JWR Ventures Manufacturing Building Permit Responses

Harnett County Permitting
420 McKinney Parkway
Lillington, NC 27546

Planning

DRAWING NUMBER
G-111

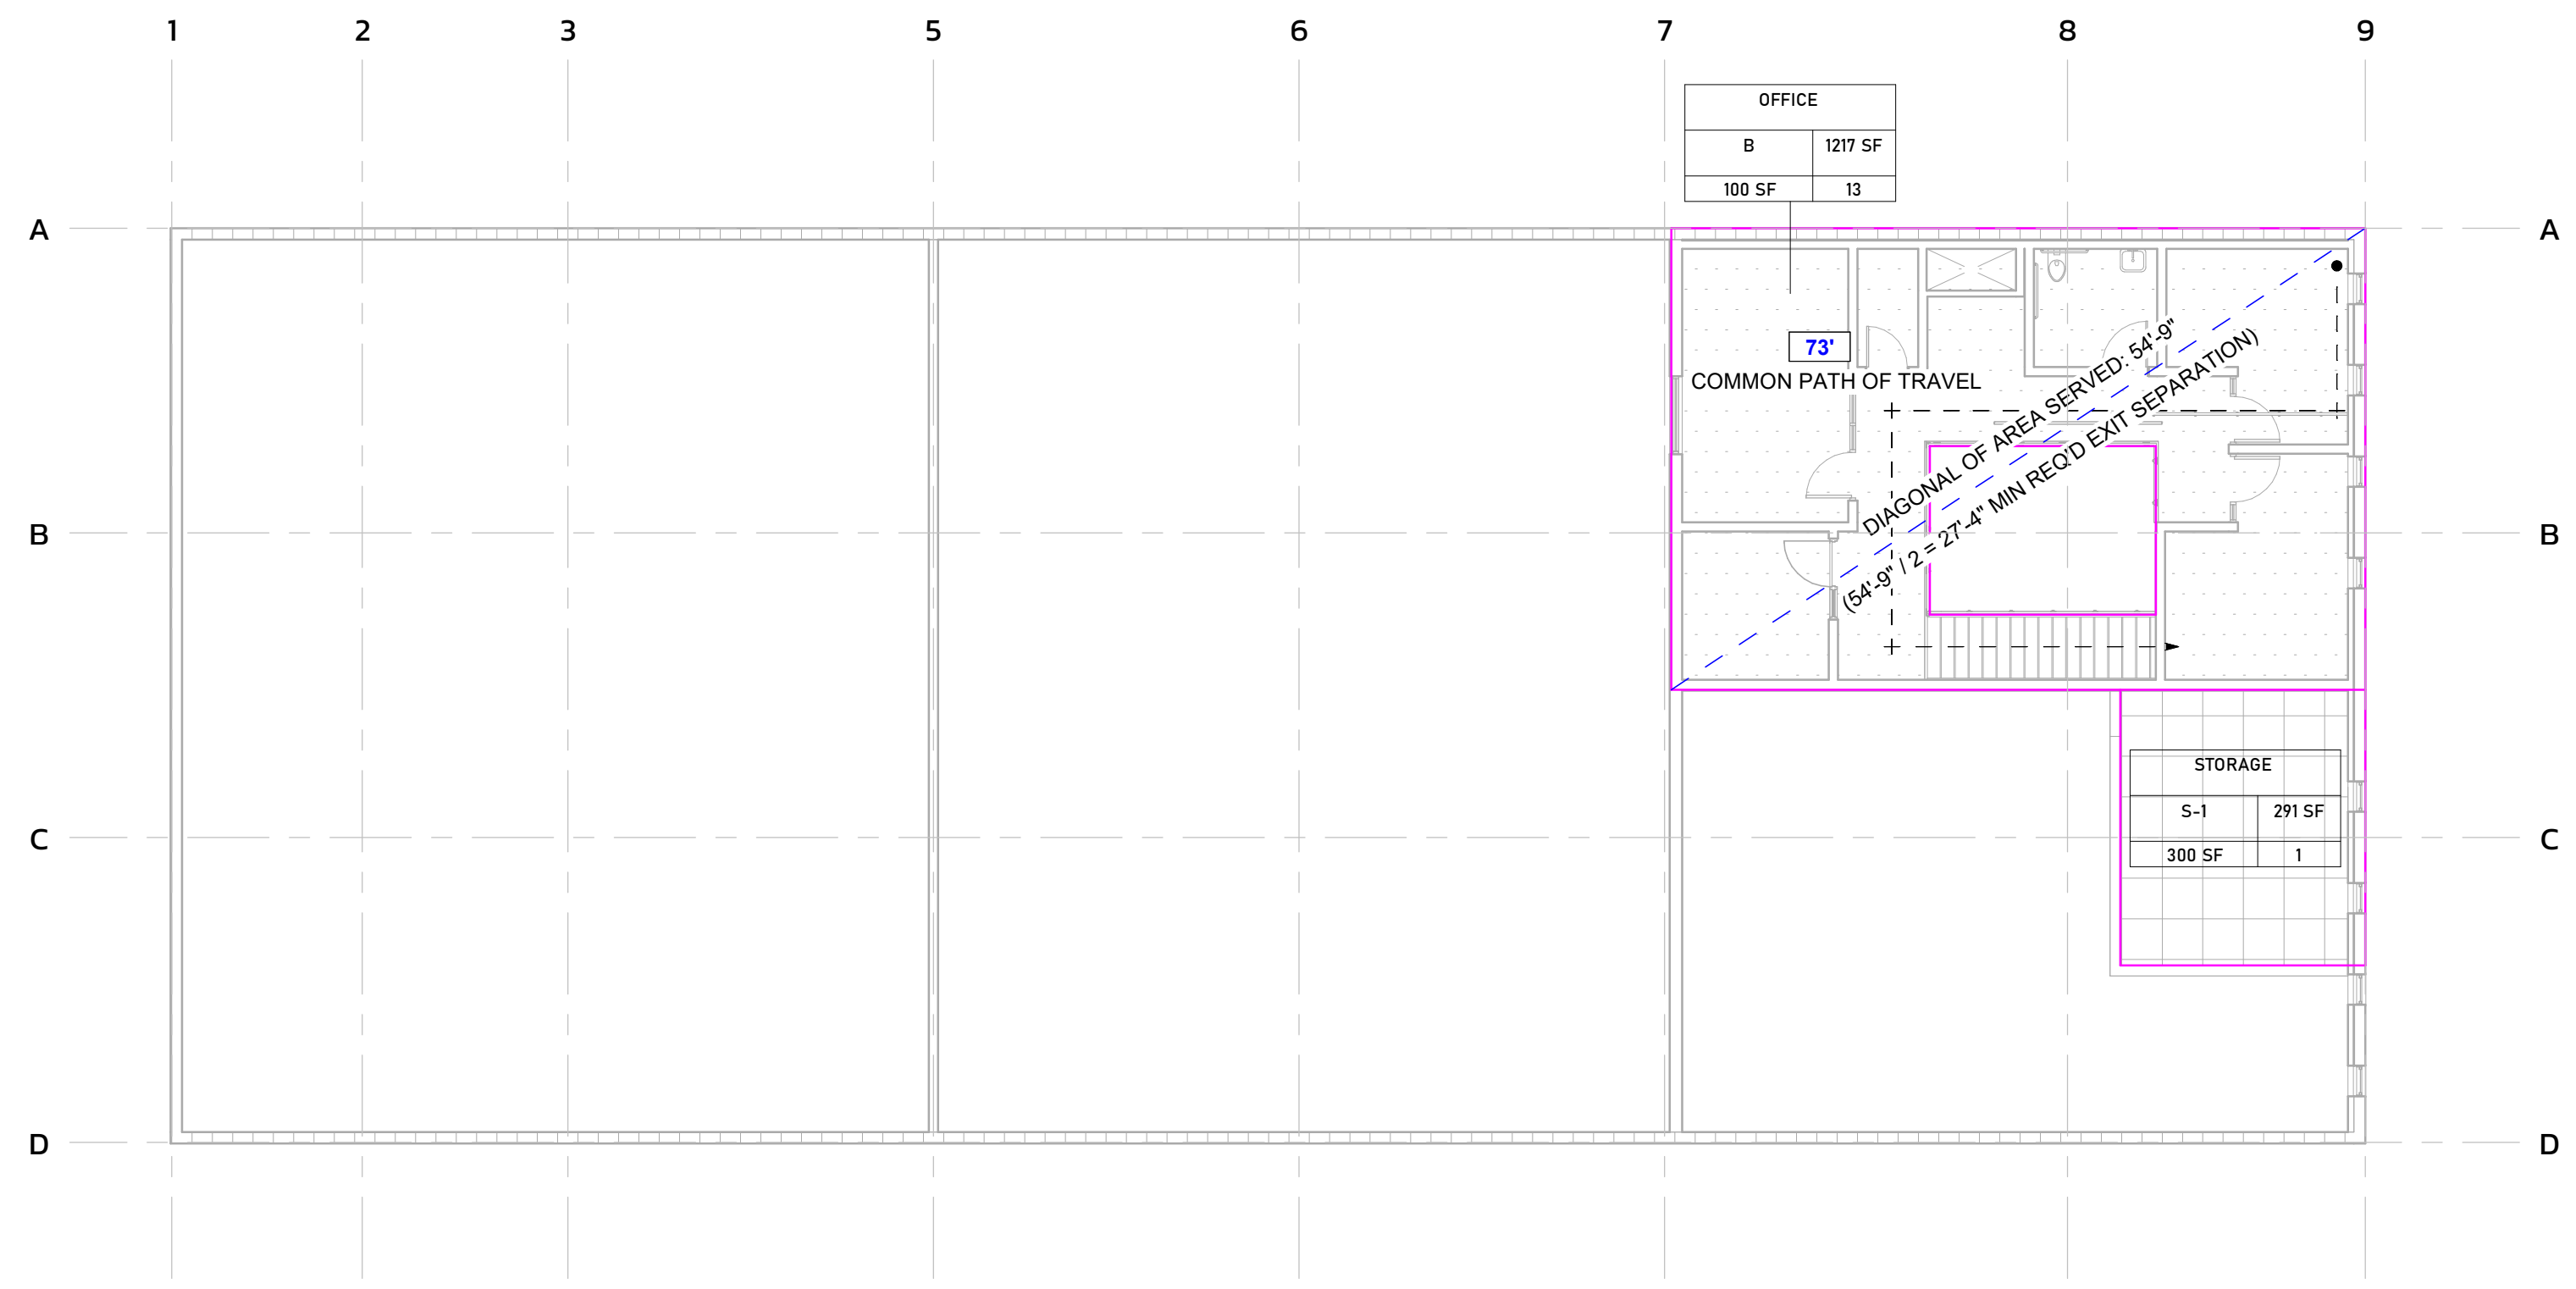
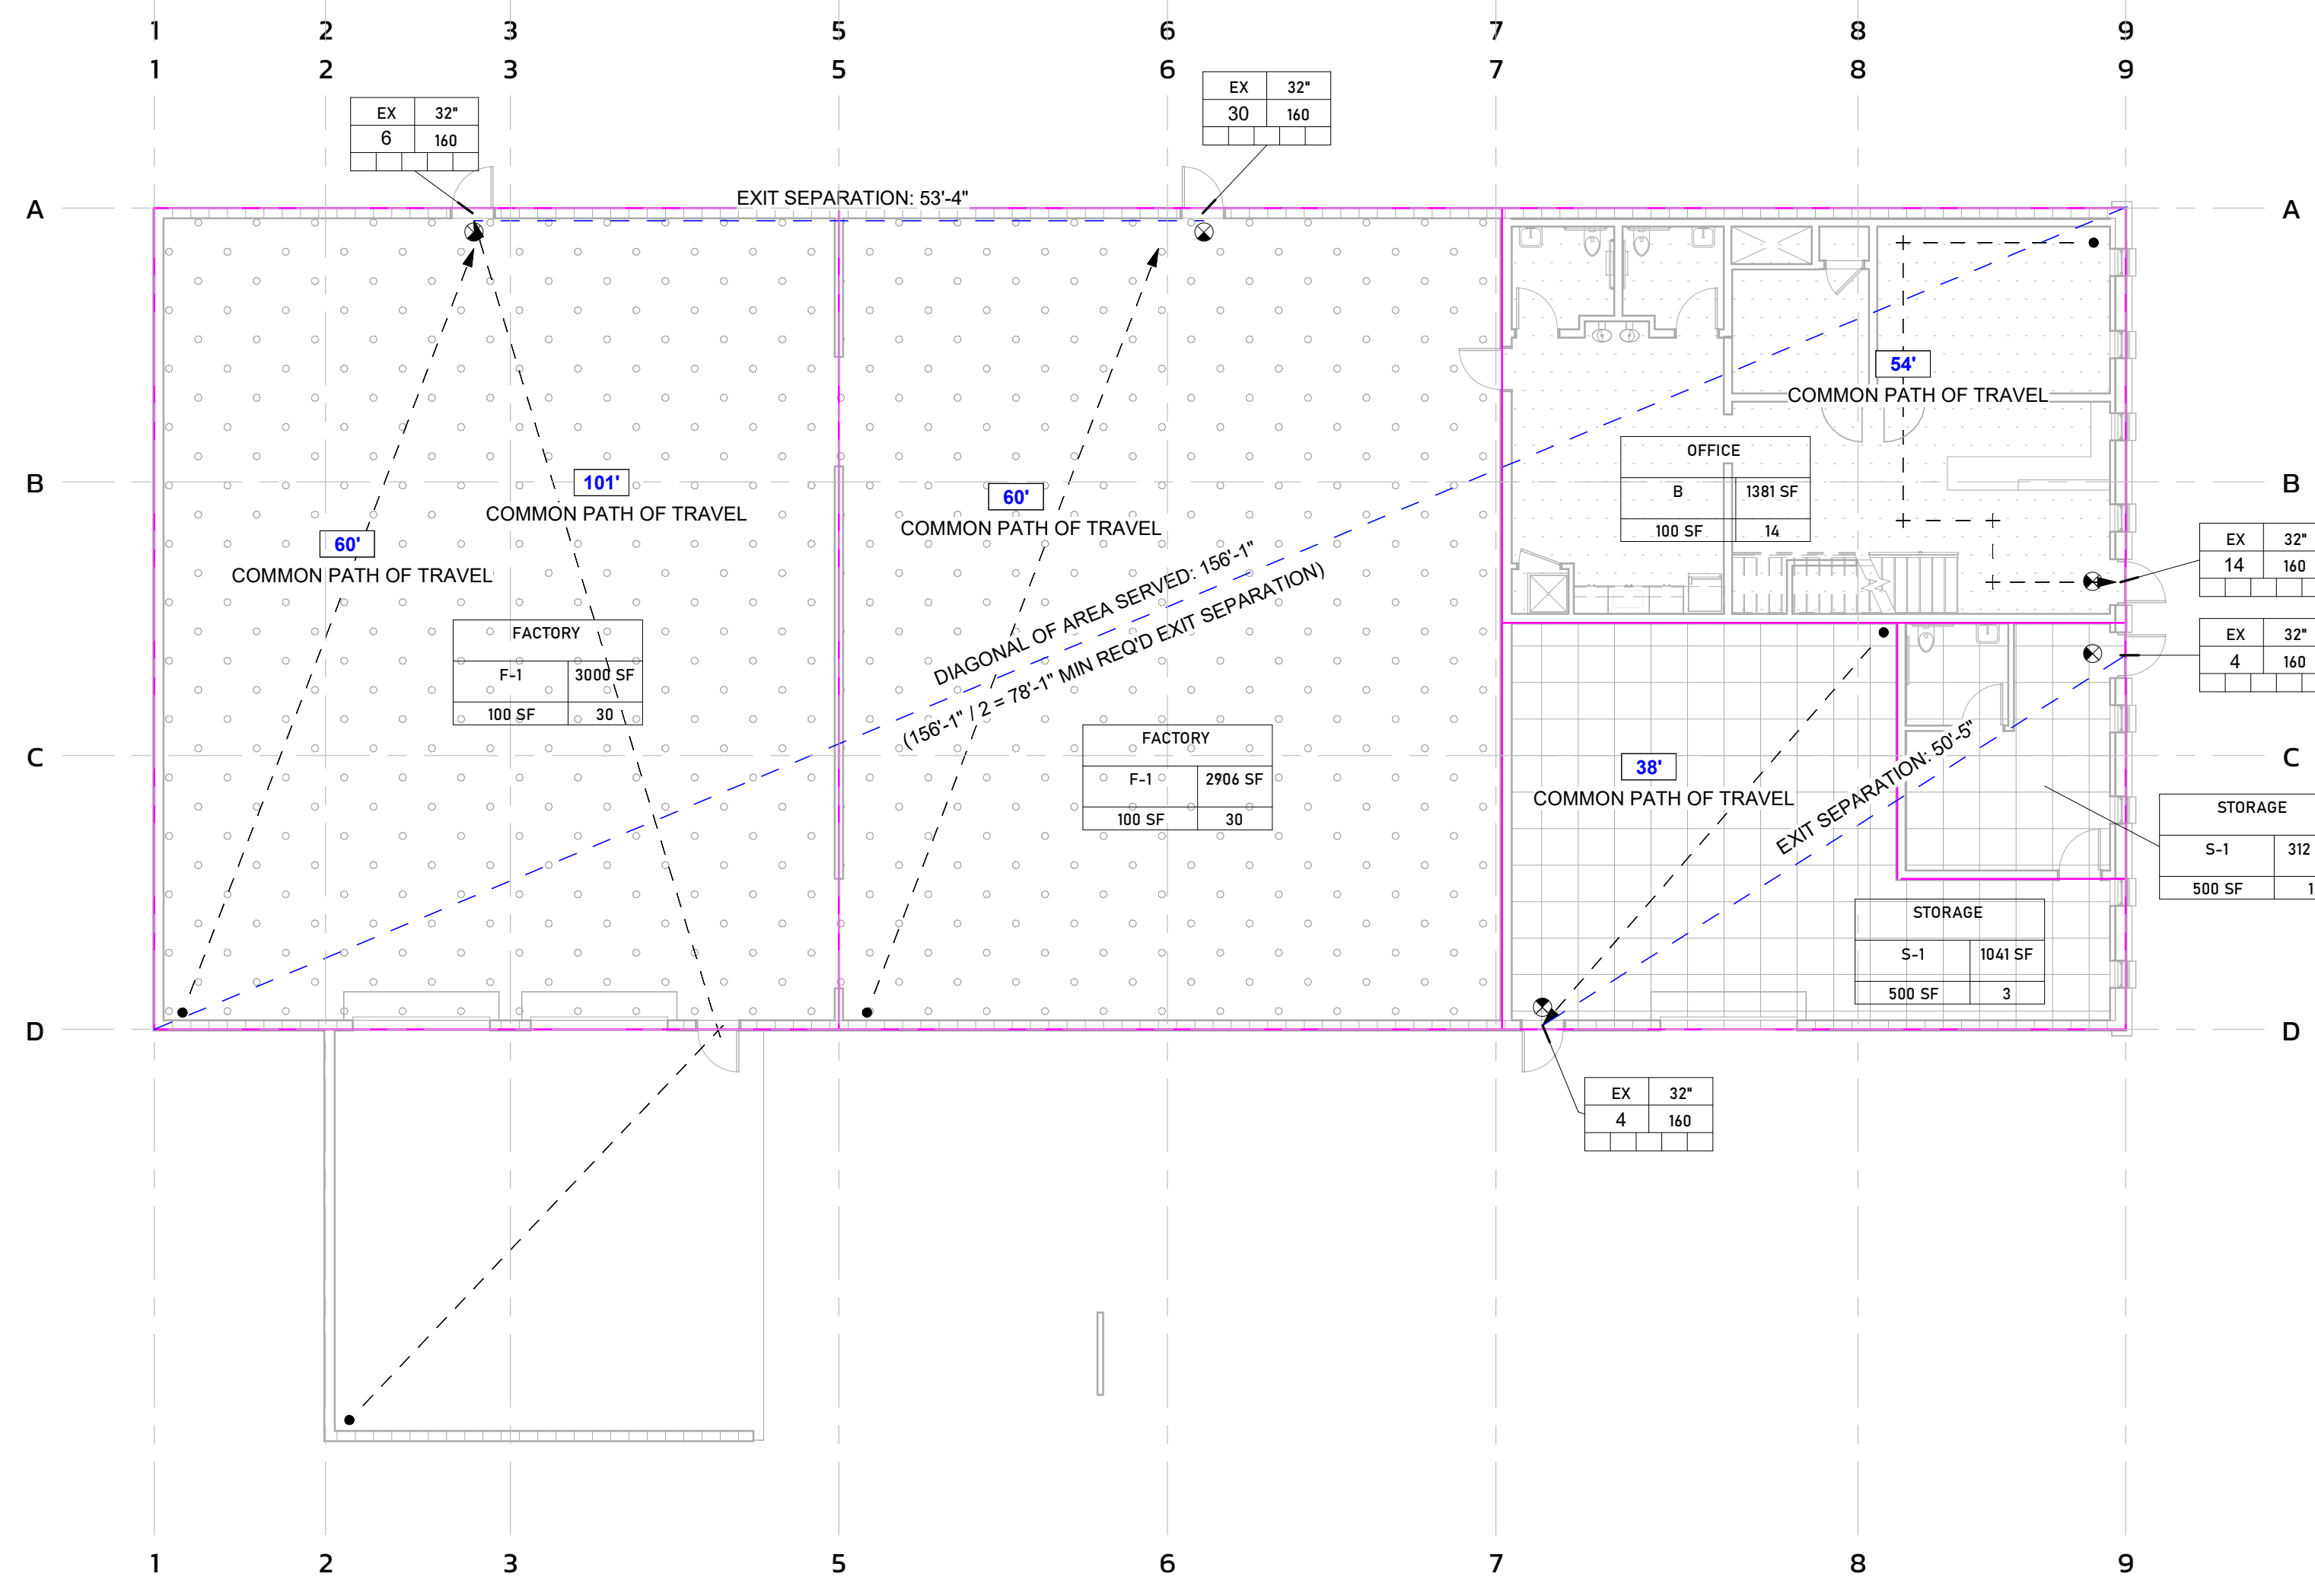
1. Provide information on floor sheathing detail 6 S4.1 penetrating 2 hour wall. **Architectural plans have updated to be nonseparated mixed use, all rated walls removed. See updated set.**
2. Provide information on electrical installation of devices in 3 hour wall. 714.3.2 allows installation in 2 hour wall max. **Architectural plans have updated to be nonseparated mixed use, all rated walls removed. See updated set.**
3. Provide UL details of through penetrations to be used on 3 hour wall for all trades. **Architectural plans have updated to be nonseparated mixed use, all rated walls removed. See updated set.**
